**KIRKLEES METROPOLITAN COUNCIL
INVESTMENT & REGENERATION SERVICE**

DELEGATED DECISION TO DETERMINE PLANNING APPLICATIONS

Reference No:	2025/62/93351/E
Site Address:	41, Batley Field Hill, Upper Batley, Batley, WF17 0BE
Description:	Erection of extensions and alterations to existing dwelling with detached outbuilding to rear
Recommending Officer:	Jennifer Booth

DECISION - REFUSED

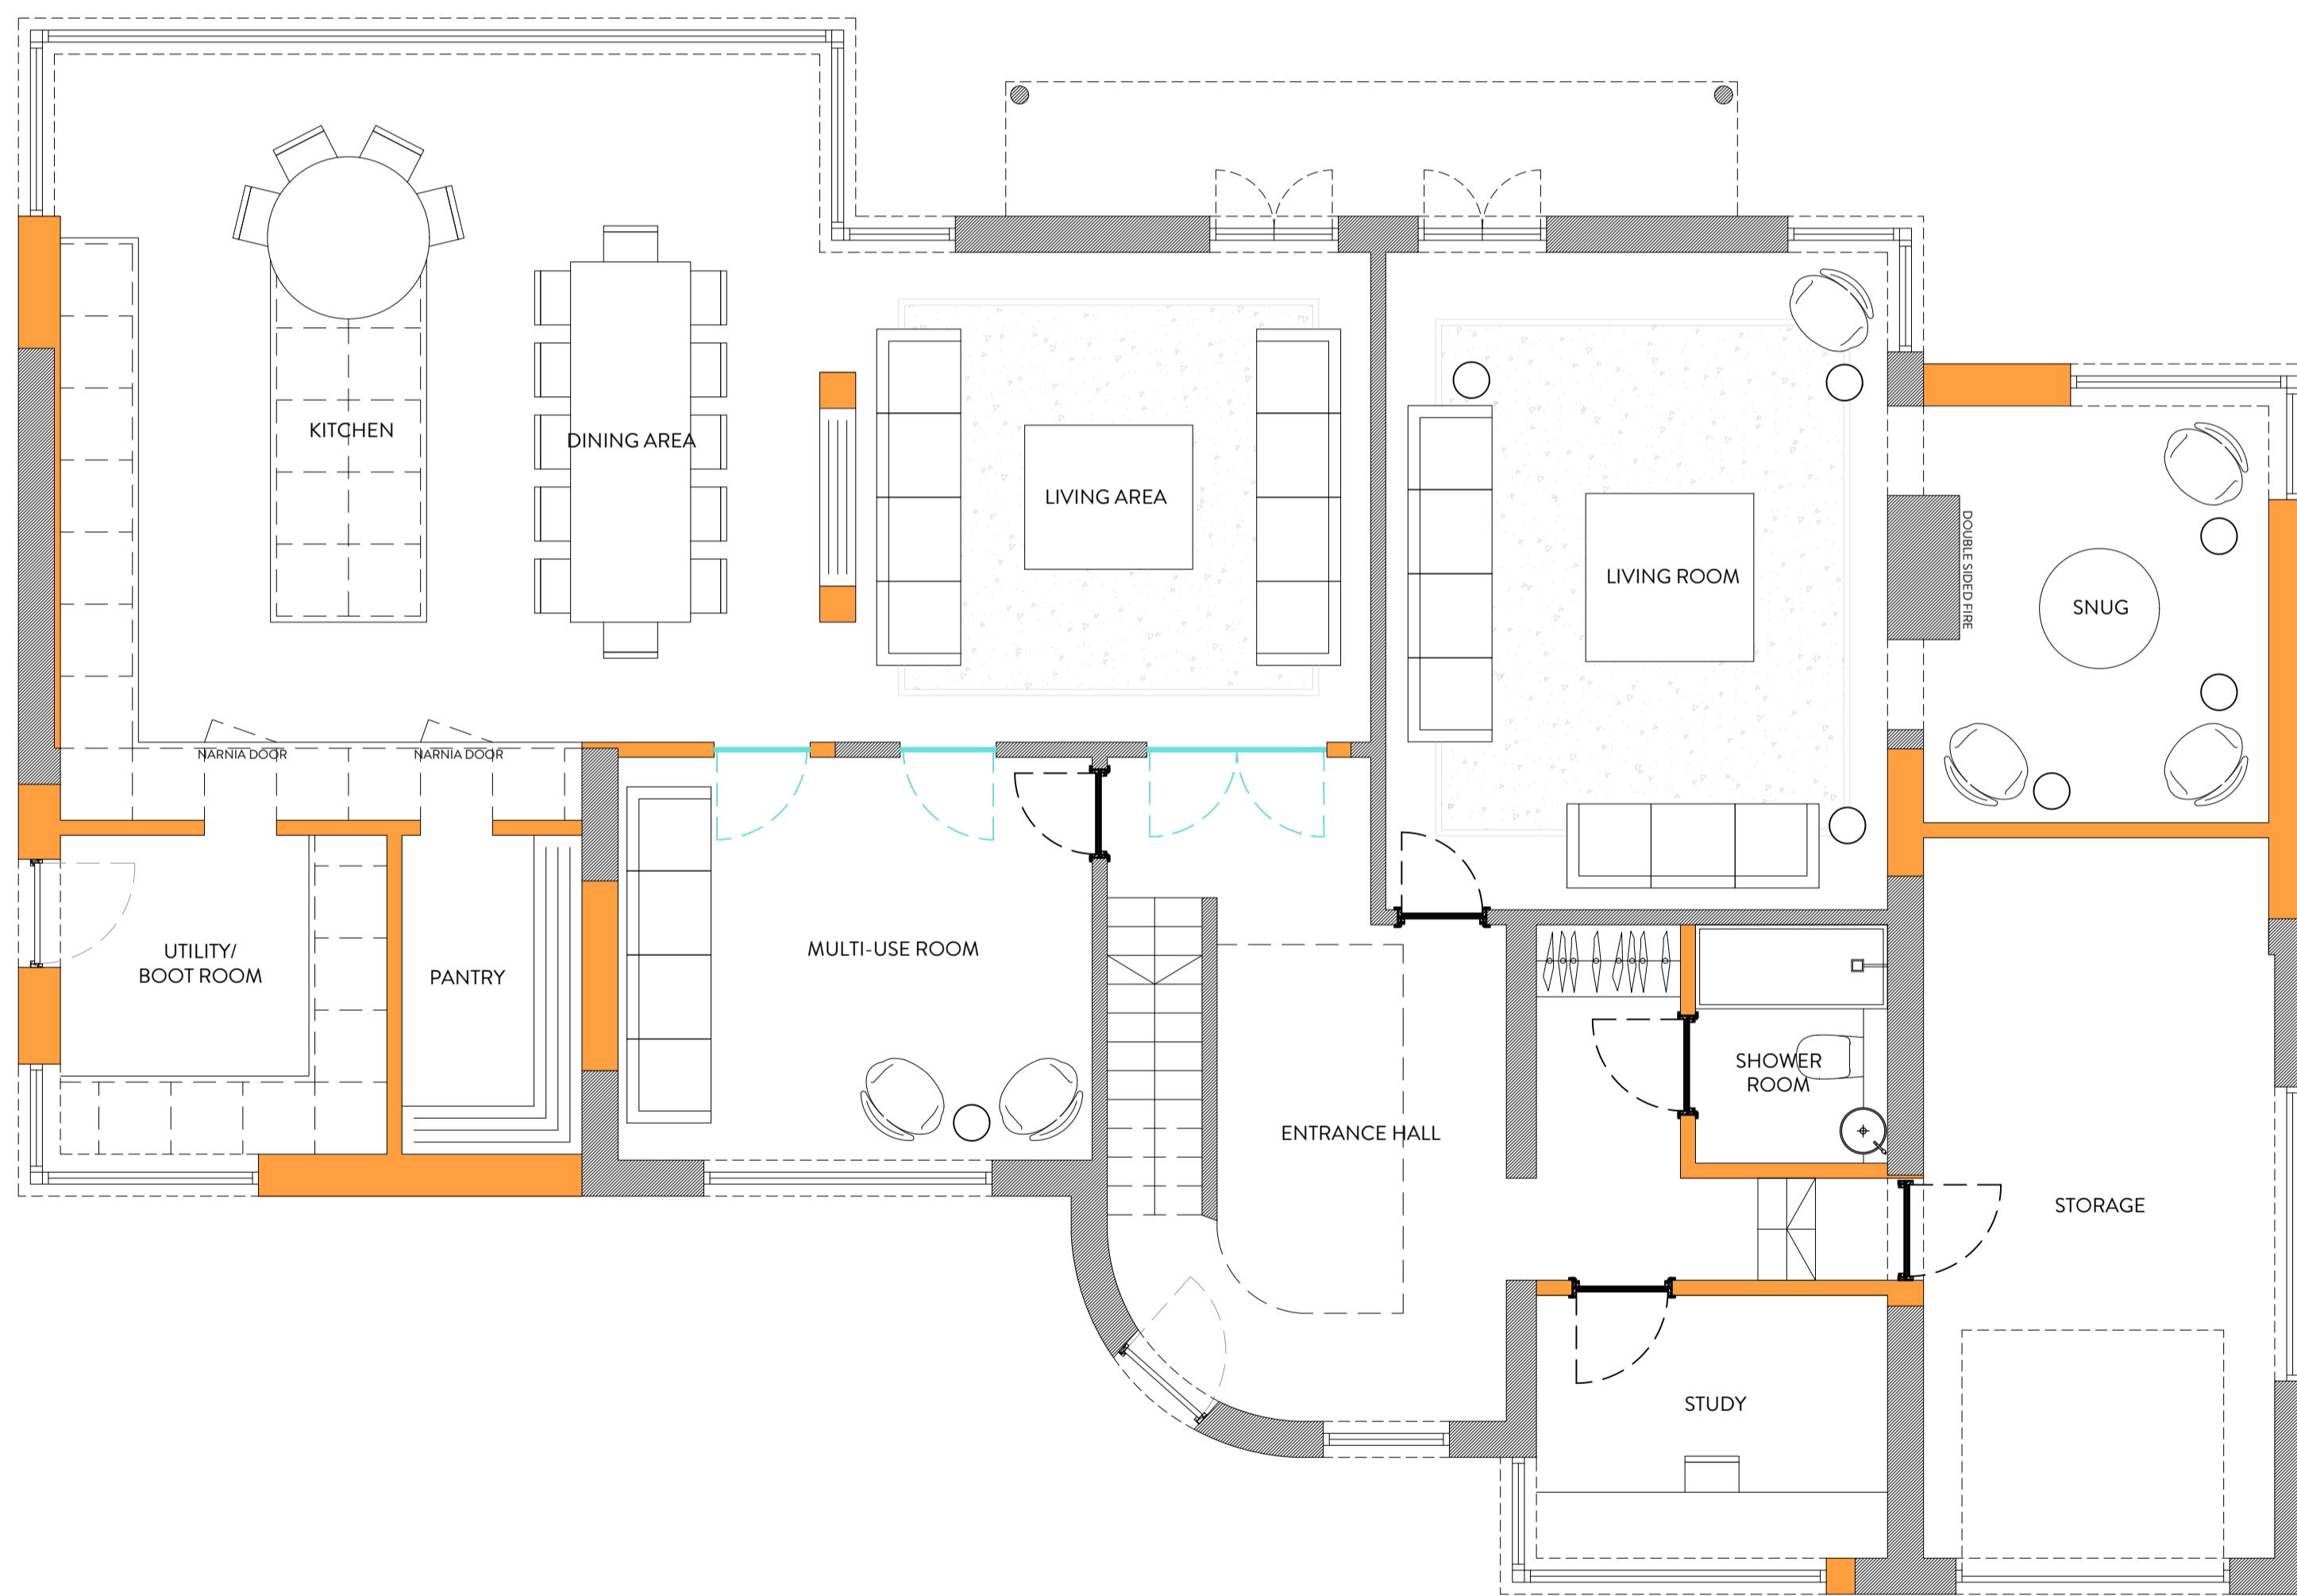
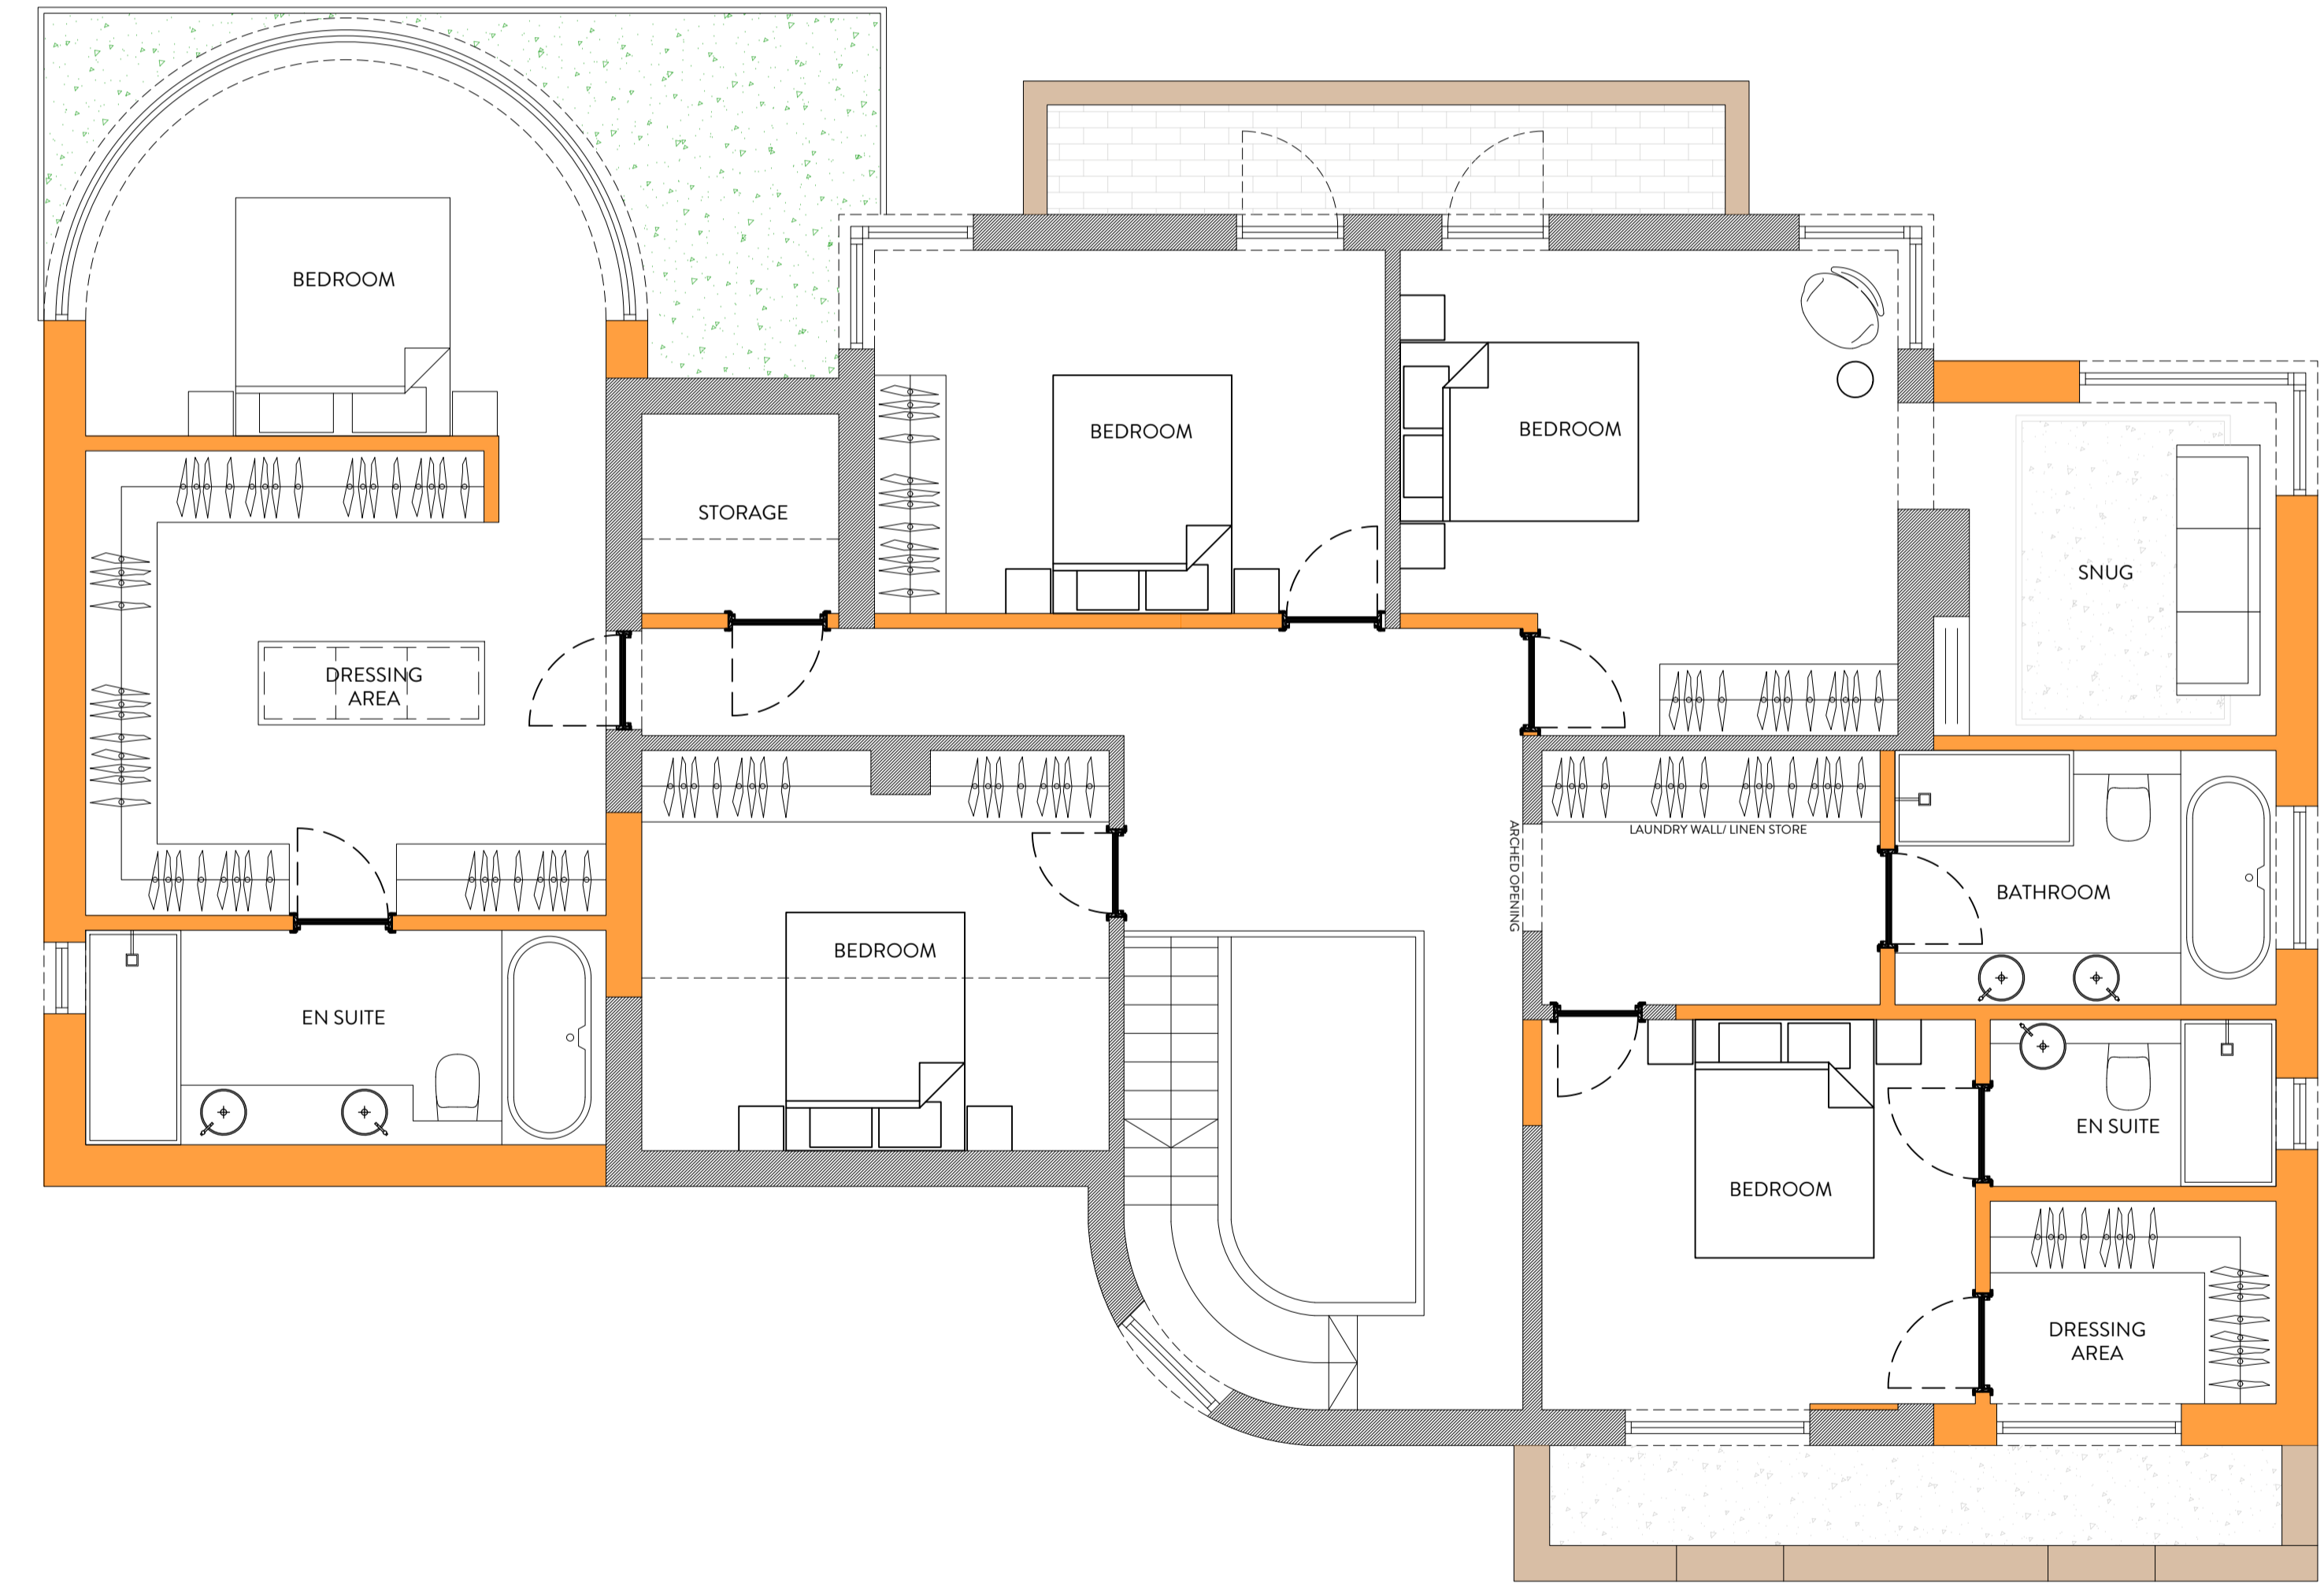
The application site comprises a well-preserved Art Deco dwelling dating from 1935, designed by A. L. Abbot, and recognised as a non-designated heritage asset by virtue of its architectural interest and inclusion on the UK Modern House Index. The proposed extensions and alterations fail to preserve the character and significance of the host property. In particular, the first-floor extension above the garage lacks subservience due to its height and massing, disrupting the original proportions of the building. The introduction of a gabled roof form, front-facing rooflights and revised fenestration on the principal elevation conflicts with the strong horizontal emphasis, restrained roofscape and balanced composition that define the Art Deco character of the dwelling. The resulting solid-to-void relationship appears awkward and visually discordant.

The proposed development would result in an unacceptable impact on the visual amenity of the site and its surroundings. The scale, height and massing of the first-floor extension above the garage would appear overly dominant and visually intrusive, failing to read as a subordinate addition and disrupting the established proportions of the host dwelling. The introduction of a gabled roof form, front-facing rooflights and revised fenestration on the principal elevation would create a visually cluttered and unbalanced appearance, at odds with the simple, coherent composition of the existing building. This would result in an awkward solid-to-void relationship and a loss of visual clarity when viewed from the street. In addition, the proposed outbuilding, by reason of its design and lack of visual alignment with the main house, would appear incongruous within the site, further detracting from the overall visual coherence of the plot. When assessed cumulatively, the proposals would give rise to a discordant and visually harmful form of development that fails to respect the appearance of the host property and would negatively affect local visual amenity.

Officers also remain concerned about the side extension, overall roof profile and the proposed outbuilding. While the agent has cited avoidance of a two-storey flat-roofed side extension as an improvement, the art deco style of the property would respond to the use of the flat roof form previously approved. The omission of previously approved elements, and the suggestion that some works could be undertaken under permitted development, do not carry weight in the assessment. Furthermore, the outbuilding is considered to contribute to visual clutter within the site and does not reflect the scale, form or character of typical ancillary development, and proposed amendments would not overcome these fundamental concerns. Overall, Officers conclude that the proposal would fail to preserve the character and appearance of the host dwelling and wider street scene and is therefore contrary to relevant design policies.

1. The proposed extensions and alterations, by reason of their scale, height, massing, roof forms and fenestration, fail to preserve the character and significance of the non-designated heritage asset. Due to the scale and design the development would not appear subservient and the cumulative impact would erode the building's distinctive architectural qualities and coherent design. The proposal therefore results in harm to the character and significance of a non-designated heritage asset, contrary to Policy LP24 and LP35 of the Kirklees Local Plan, the House Extensions & Alterations SPD, and the aims of Chapter 12 and 15 of the National Planning Policy Framework.

2. The proposed development, by reason of its form, scale, height and layout, would appear overly dominant and visually discordant with the simplicity of the host, failing to read as a subservient addition. The resulting development would disrupt the proportions, symmetry and simplicity of the building, creating an unbalanced and awkward appearance that is harmful to the visual amenity of both the host property and the wider street scene. The proposal is therefore contrary to Policy LP24 of the Kirklees Local Plan, in particular criteria (a) and (c), KDP 1 and 2 of the House Extensions & Alterations SPD, and the objectives of Chapter 12 of the National Planning Policy Framework, which seek to secure high-quality and visually appropriate design.
